# Heritage Impact Assessment

**New Campus Development for  
The Ottawa Hospital  
Phase 4: Main Hospital Project  
Ottawa, Ontario**

**January 12th, 2026  
(Issued for SPC Resubmission)**

**HERITAGE IMPACT ASSESSMENT ADDENDUM 05 MEMO**  
**New Campus Development for The Ottawa Hospital**  
**Phase 4: Main Hospital**

ELEVATION - RETAINING WALL #13
1:100

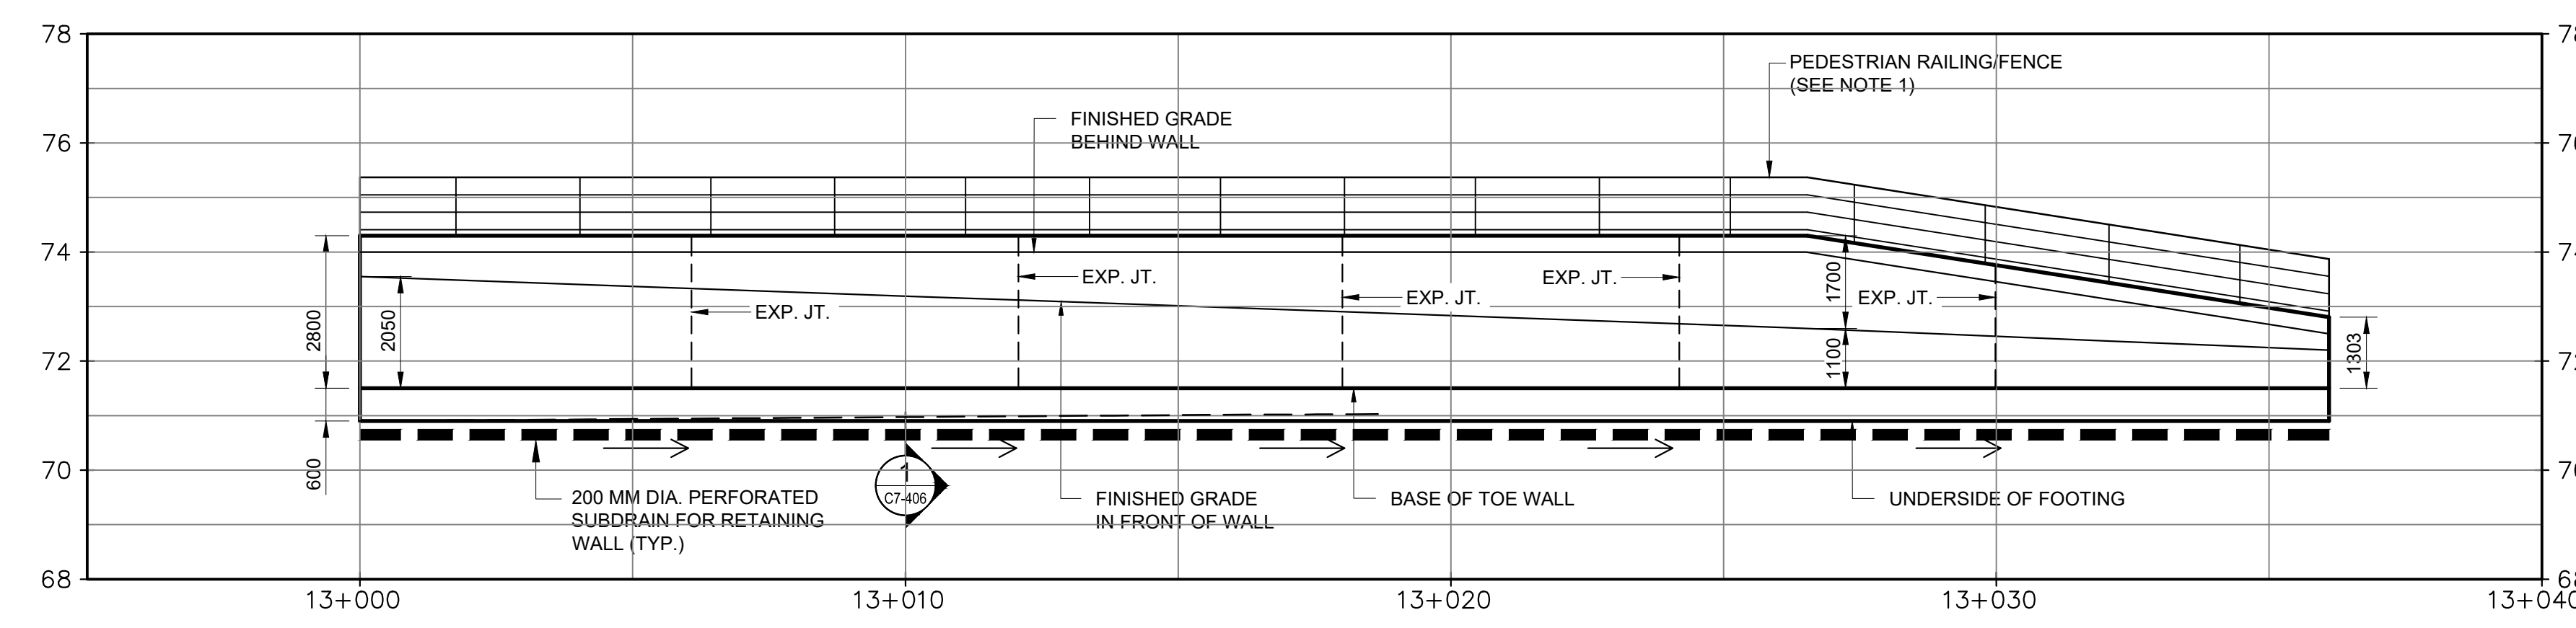
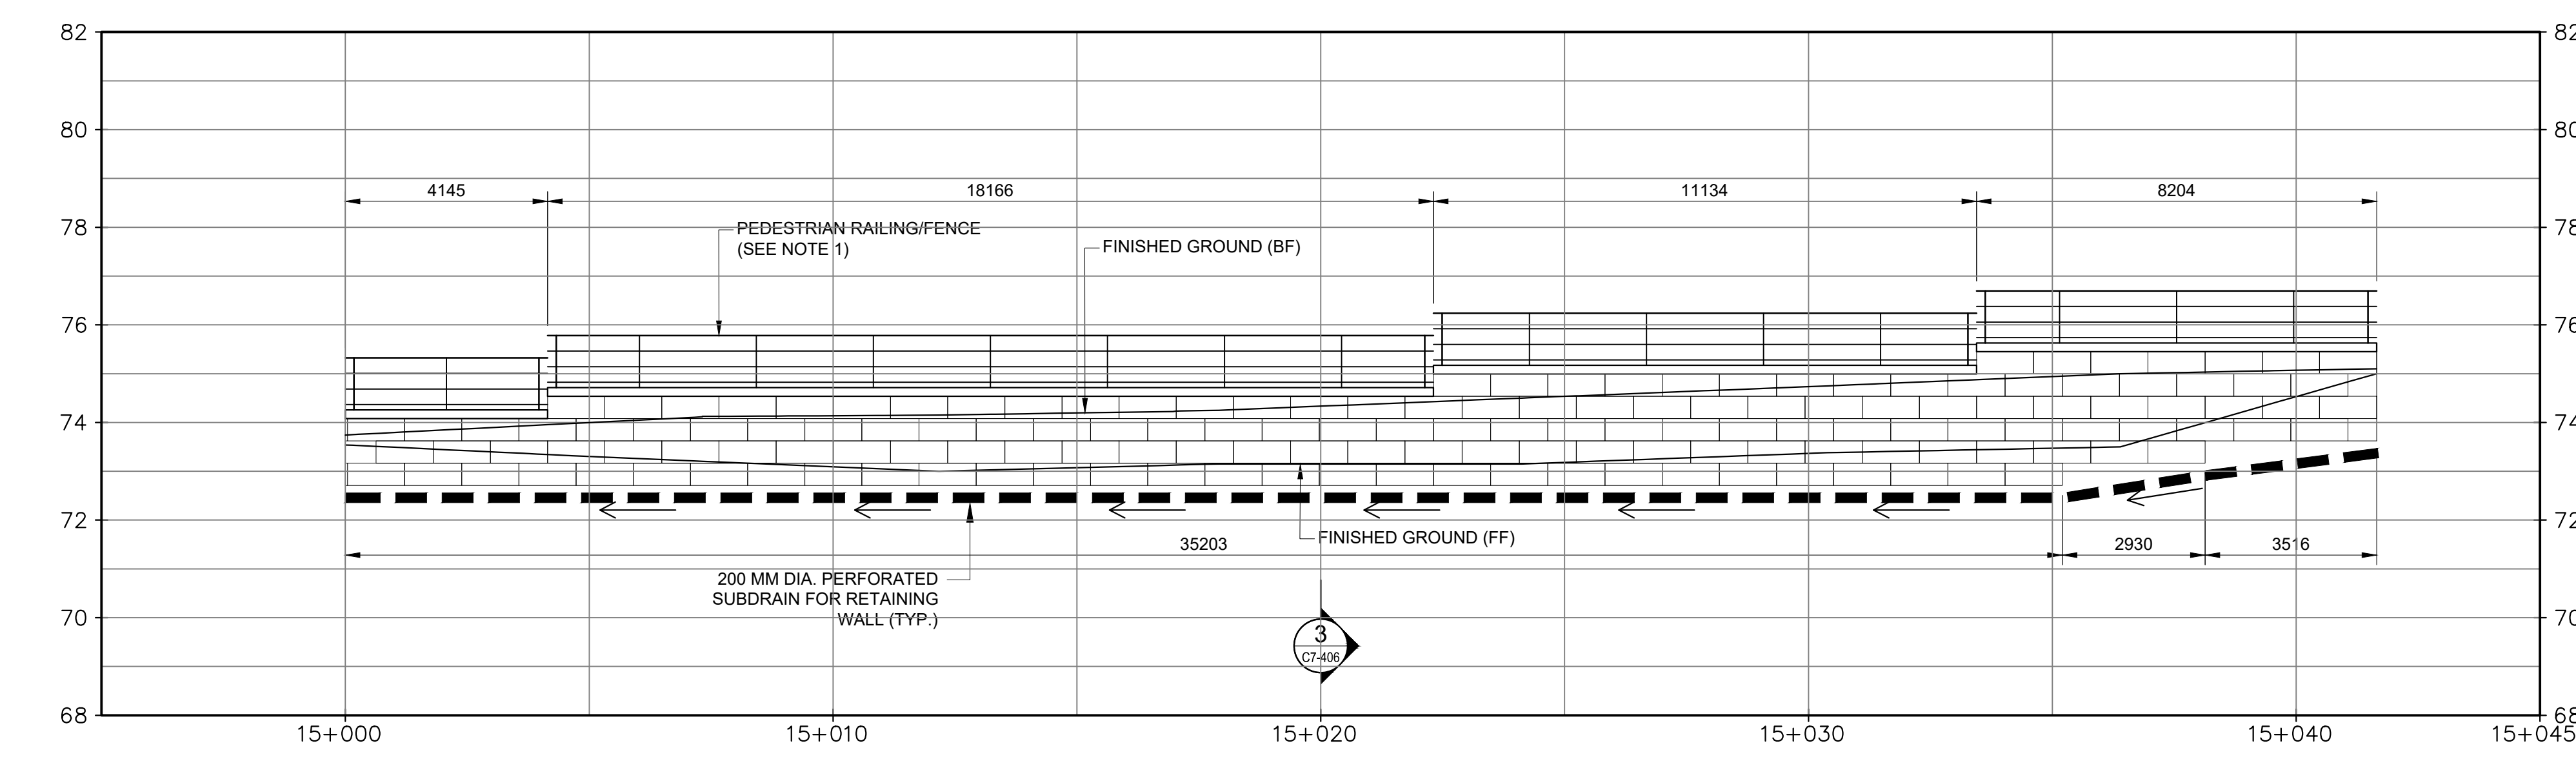
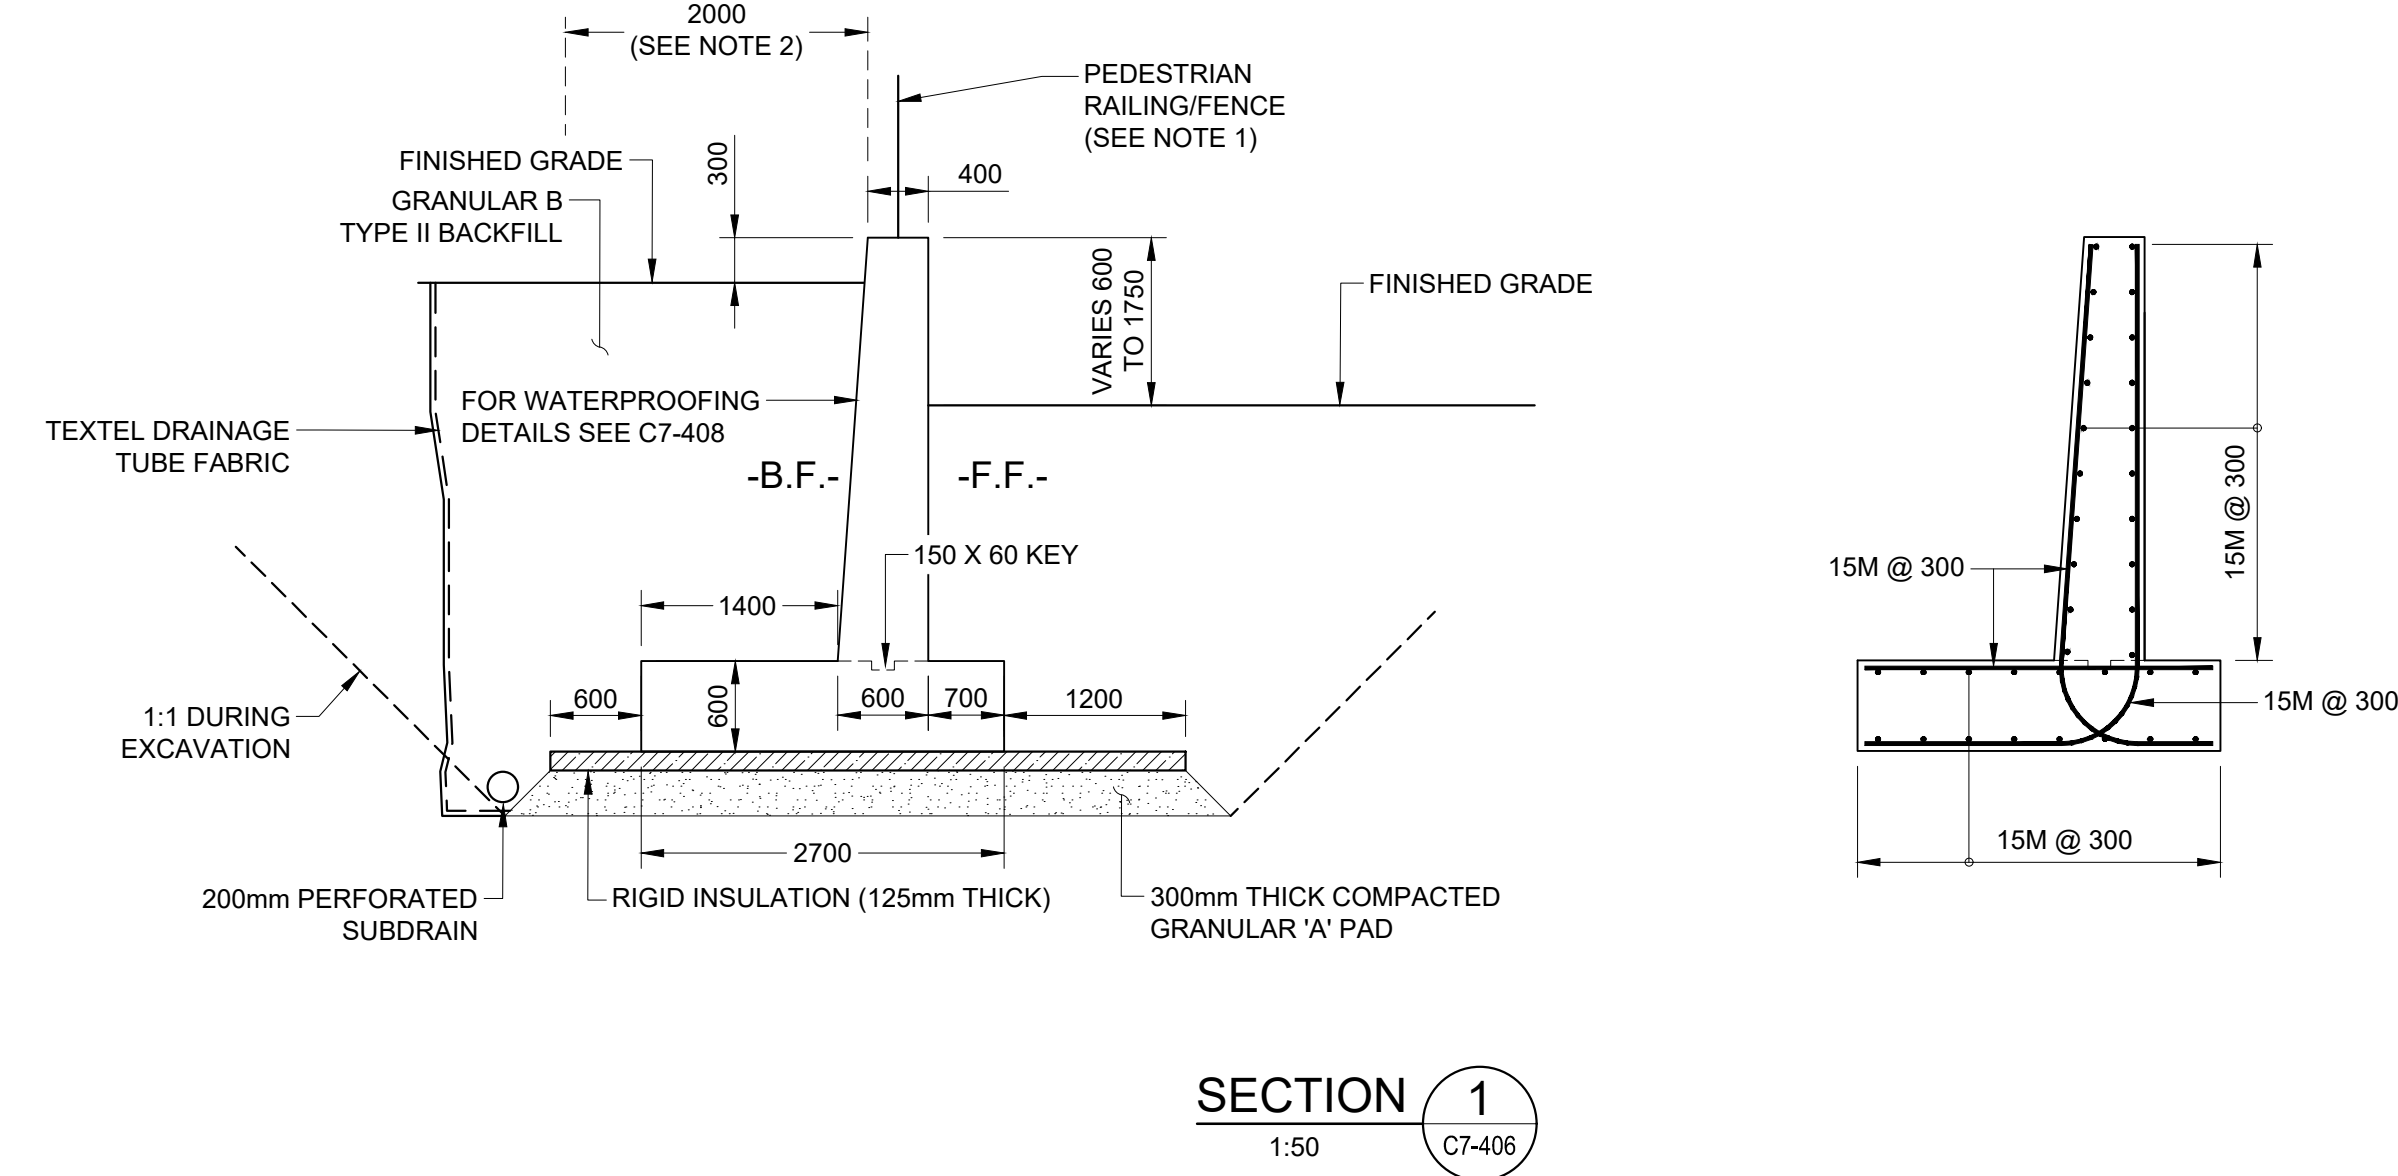
14.26 R3	<p>CHIS Add#2, Page 8 (NCC – Heritage Program, HT)          In the chart under Analysis of Impact – Alterations, there is discussion about the retaining walls on Roads D and E and their minimal impact. The proposed precast modular gravity wall should be better understood in terms of its impact. The renderings provided are insufficient. There</p>	<p>Noted (July 2025)          The design is in keeping with the design aesthetic chosen for the Campus (Stone Strong – Chiseled Granite) as confirmed with the Advance Works Approvals. The retaining wall is within Hospital Leased Lands. The federal stakeholders NCC and AAFC were consulted and reviewed the proposed Stone Wall System in November 2024 and confirmed (per email received from NCC dated November 1, 2024) that the lower heights, placement of the bike storage building, addition of vegetation, and the setbacks do assist to mitigate the impact on views to and from Prince of Wales Drive and the CEF. It was therefore recommended that TOH proceed with the Stone Strong Chiseled Granite System.</p>

14.32 R3	CHIS Add#2, Modeled Views (NCC – Heritage Program, HT) Views 18 and 19 are insufficient to assess the impact of the materiality of the retaining wall and fence on the cultural landscape of the CEF	Noted (July 2025). The materiality of the retaining wall and fence are not part of the Main Hospital scope and are included in Advanced Works.
<b>14a_CA0038206.3095_ OH CUP - CHIS Aug 9 2024 Submission</b>
